Application No: R/59/21/HH
Site Address: 9 Amberley Road Rustington BN16 2EF
Description of works: Extension of existing main roof over existing ground floor. Conversion of loft Space to create Master Bedroom. Construction of dormer to north roof slope.

Thank you for your internet representation made on 29th April 2021 which has been recorded as no objection with the comments as follows:

Side Elevation (north)

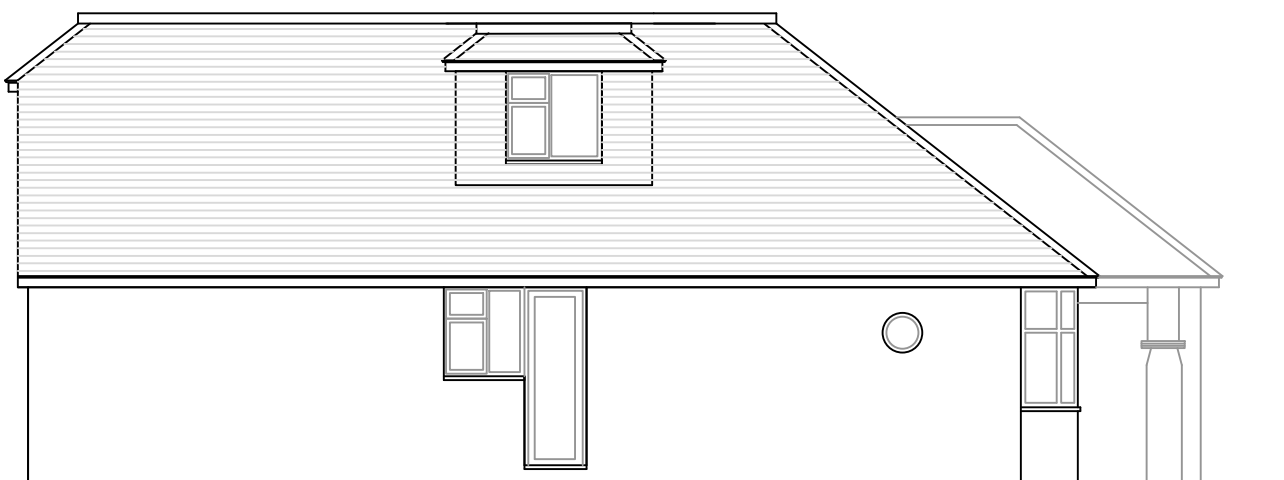
My Council has noted the above application and wishes to raise no objection to it, subject to the dormer window on the north side being opaque and non-opening.
